**Catchment Management
Authority**
Border Rivers-Gwydir

29 February 2011

**Re: Exhibition of Environmental Assessment for Sapphire Wind Farm
(Application Reference MP 09_0093)**

FIGURE 6: SOIL LANDSCAPES

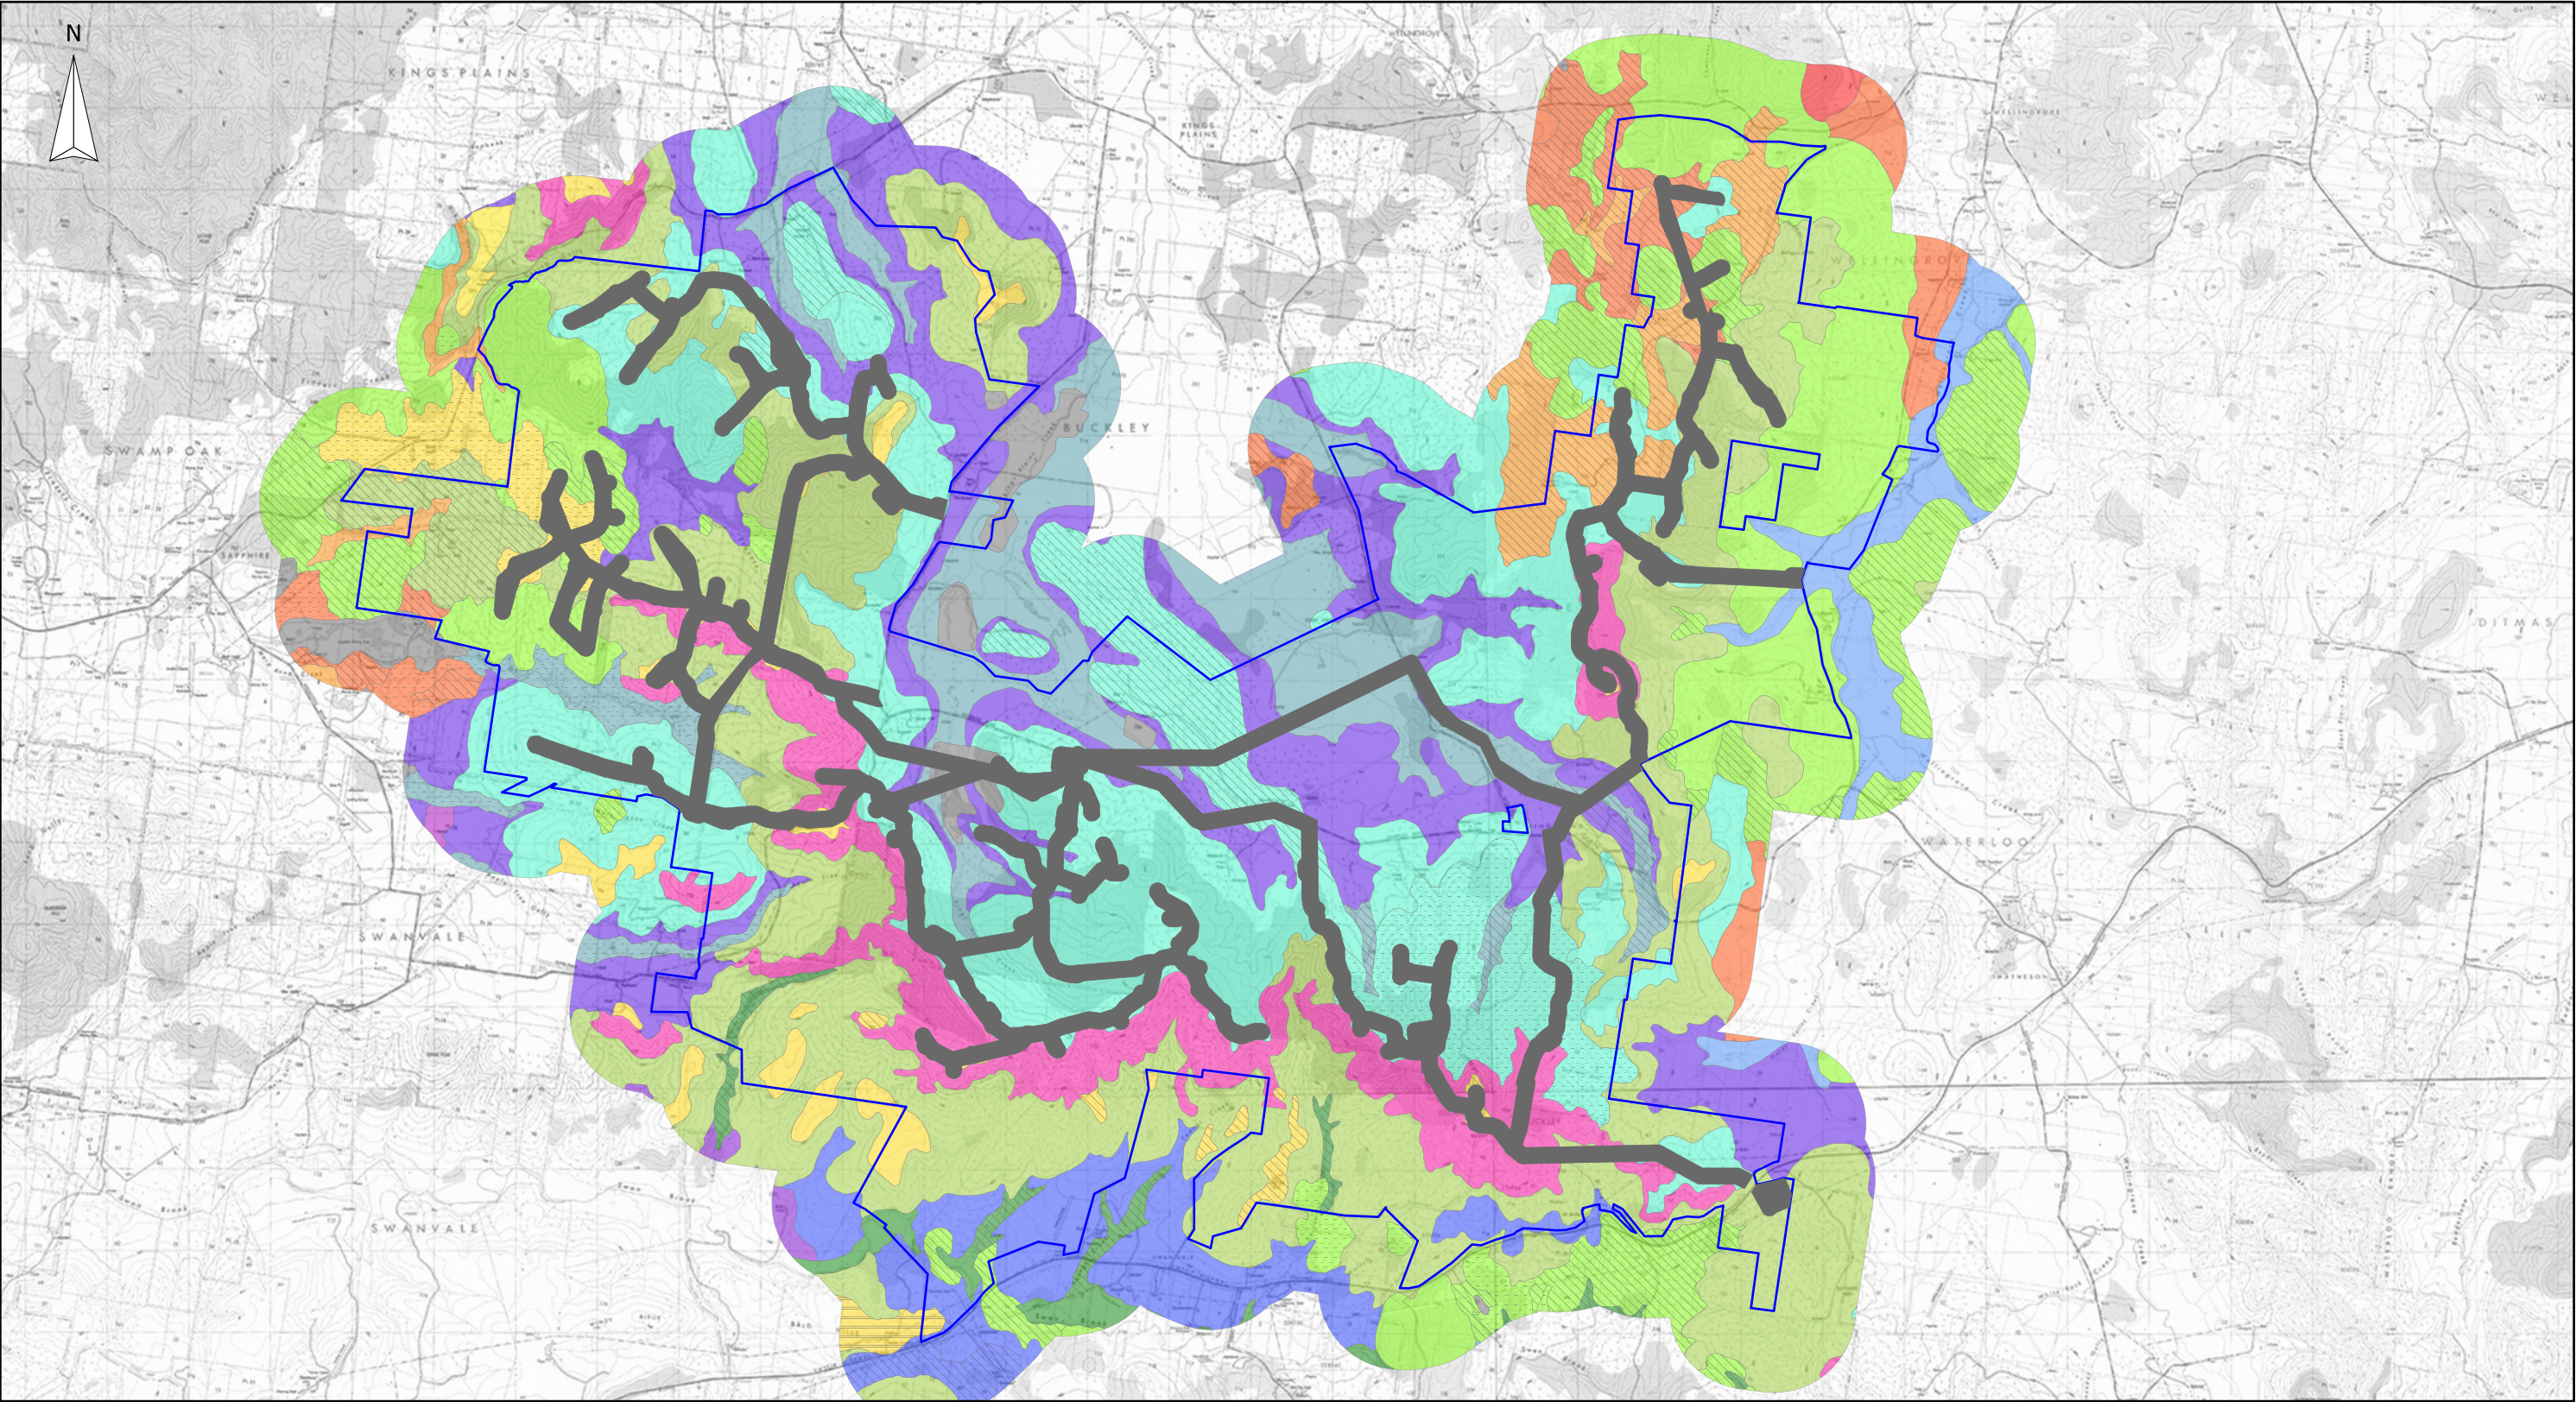
Chapter 8 of the Sapphire Wind Farm Environmental Assessment refers to the lack of published soil landscape mapping (pg. 246). We would like to draw your attention to the existence of more recent

information available from 2010. The more recent soils survey was the "Reconnaissance Soil Landscape Mapping for the Border Rivers Gwydir Catchments". It is available from the Border Rivers Gwydir CMA.

We recommend that the proponent obtain this information as it is much more comprehensive in its content to the 1977 reference. In particular, the soil landscape information provides detailed information on limitations of the soil and suitability for certain land use. To obtain information on this mapping, please contact Mark Blair, Catchment Officer based in Inverell on (02) 6728 8048.
